DECISION DELEGATED TO DEVELOPMENT MANAGER

Application No:	H02-1202-19	Applicant:	Postland Developments Ltd
Proposal:	Proposed chalet bungalow and double garage		
Location:	Land Between: 44-46 Postland Road Postland Road Crowland		
Terminal Date:	11th February 2020

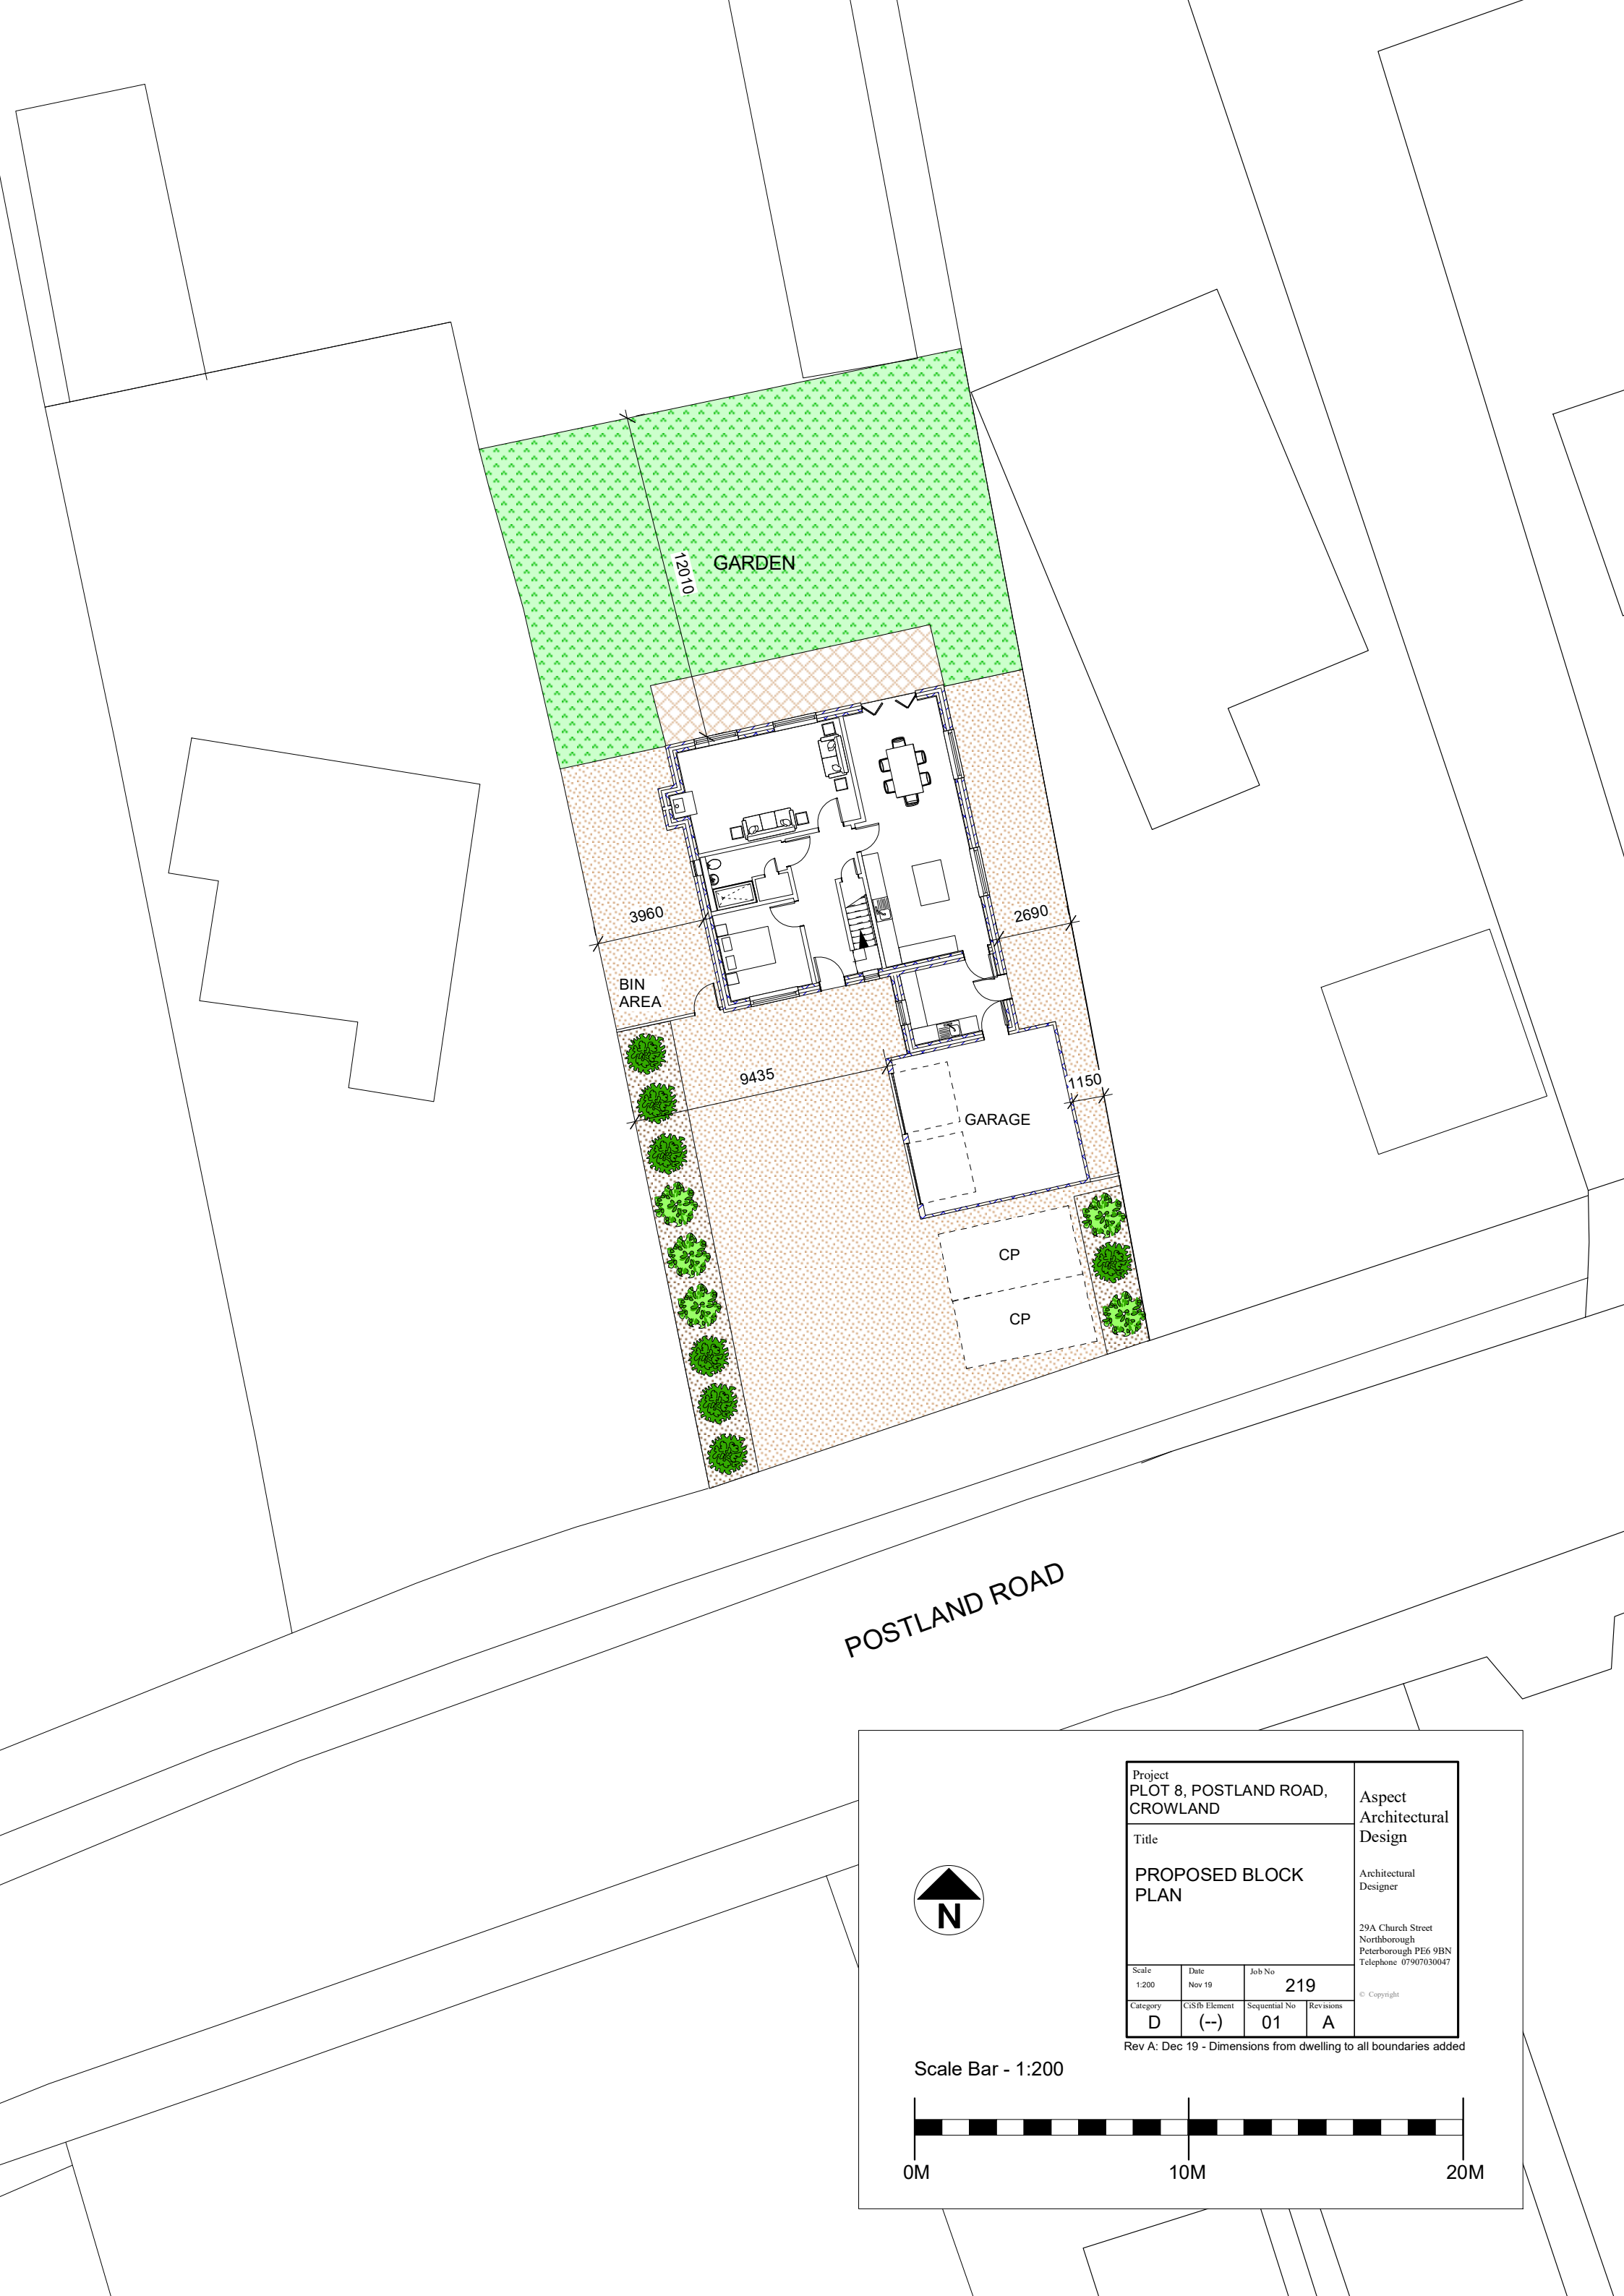
"The submitted Block Plan indicates that the vehicular access to the proposed development would be on the west side of the plot's frontage to Postland Road. There appears to be an overhead electricity supply pole on the west side of the frontage and care will need to be taken to avoid the risk of accidental vehicle collision with this pole."

"Also, the carriageway of Postland Road at the frontage of the site is drained by means of kerb offlets. There is a kerb offlet where it is indicated the access would be formed so suitable arrangements will need to be made to either relocate this kerb offlet and connect it to the existing outfall or provide a new road gully so that surface water does not collect in this area."

Requests a new access condition.

This is a matter that should not impact on the viability of the scheme and can be addressed by condition.

Project PLOT 8,POSTLAND ROAD CROWLAND				Aspect Architectural Design
Title PLOT 8 FLOOR PLANS & ELEVATIONS				
29A Church Street Northborough Peterborough PE6 9BN Telephone 07907030047				
Scale 1:100	Date Nov 19	Job No 219		
Category D	CisB Element (--)	Sequential No 03	Revisions	© Copyright

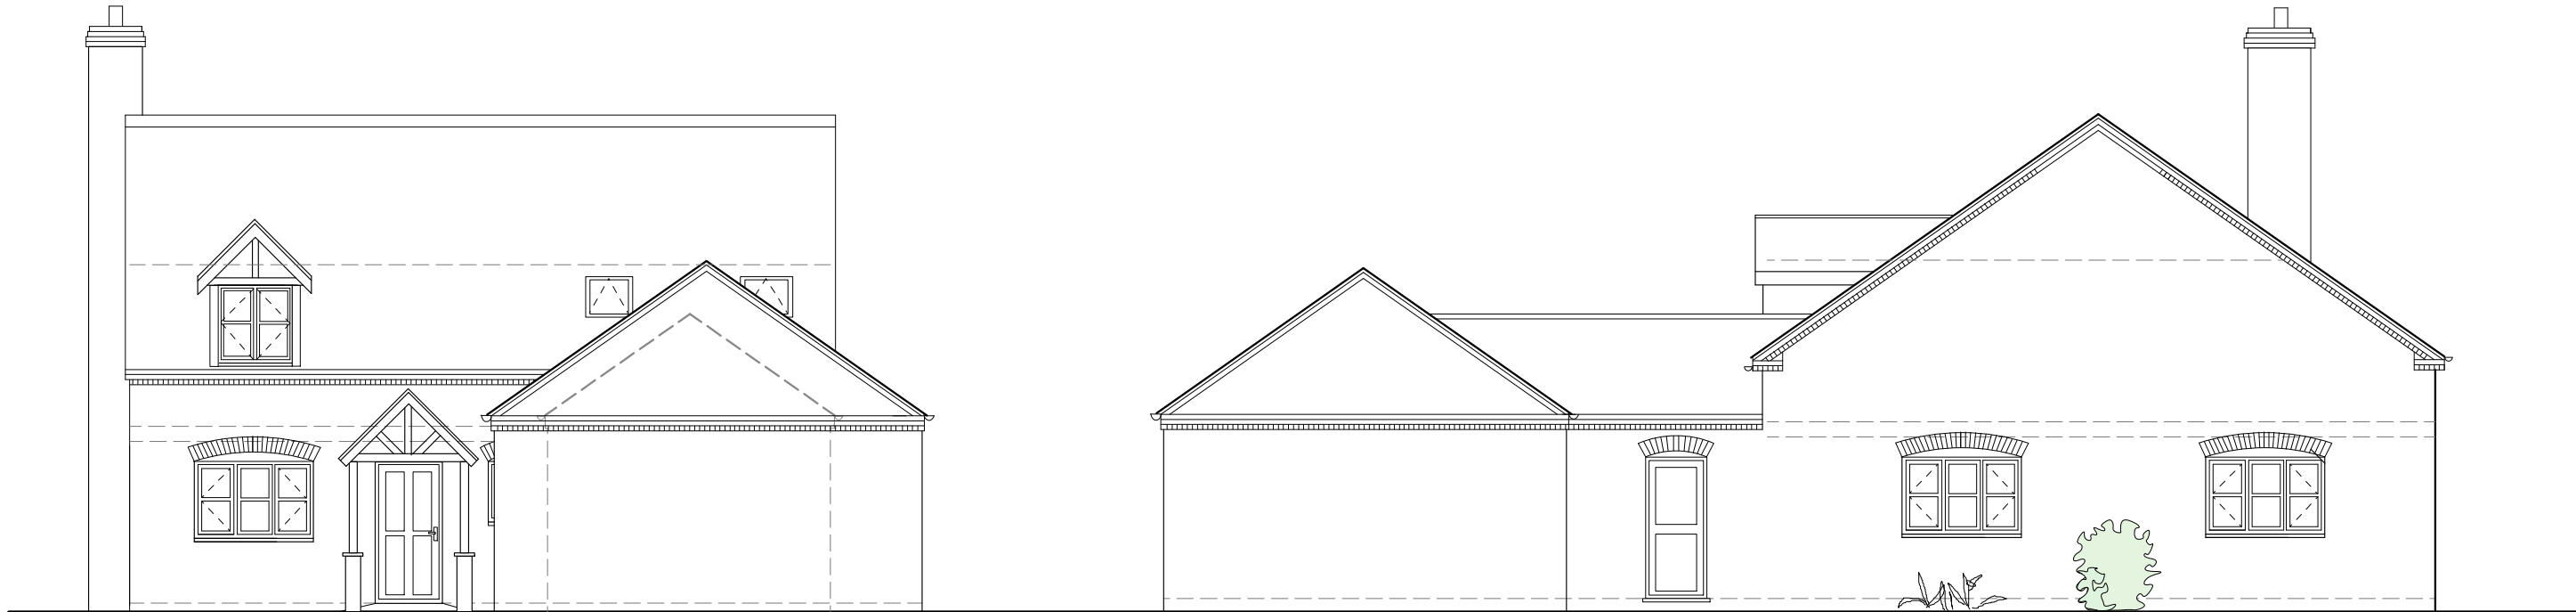
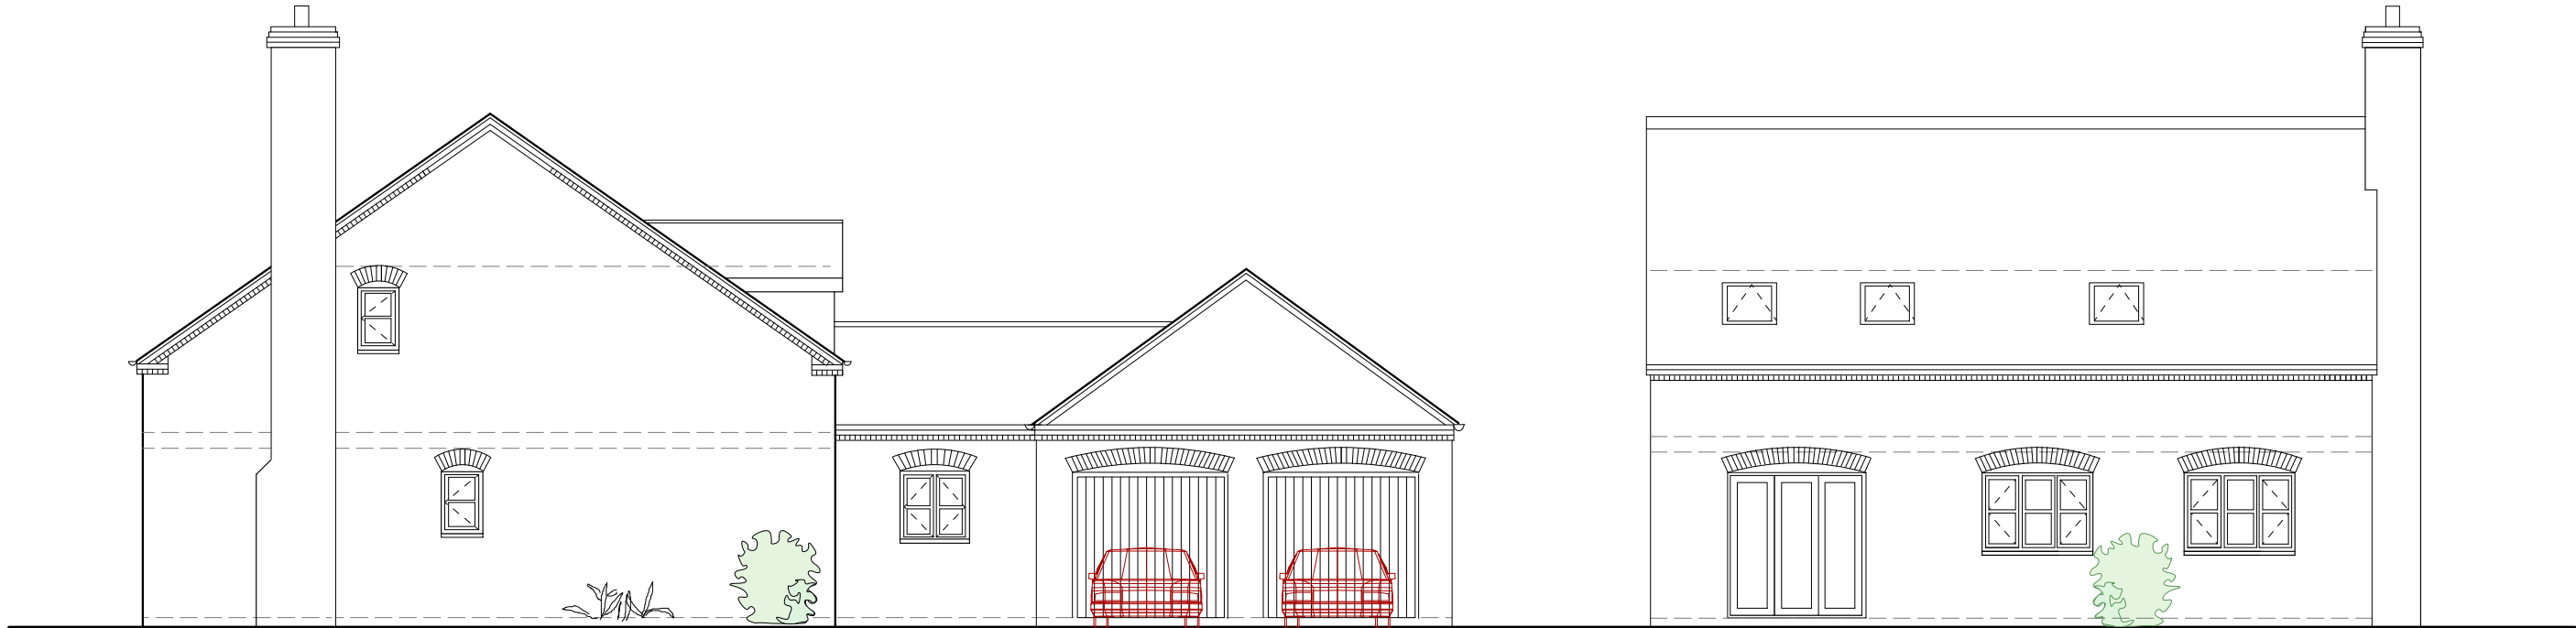
Please ensure that en-suite window is obscure glazed.

This is a full application for a chalet bungalow and double garage on Land between 44-46 Postland Road, Crowland. The proposal seeks to provide a double garage, utility room, kitchen / dining room, bedroom, bathroom and living room at ground floor level. At first floor level three bedrooms, an en-suite and a bathroom would be sited. There are no rear elevation first floor windows with roof lights providing the fenestration. The side elevation first floor window serving the en-suite would be obscure glazed.
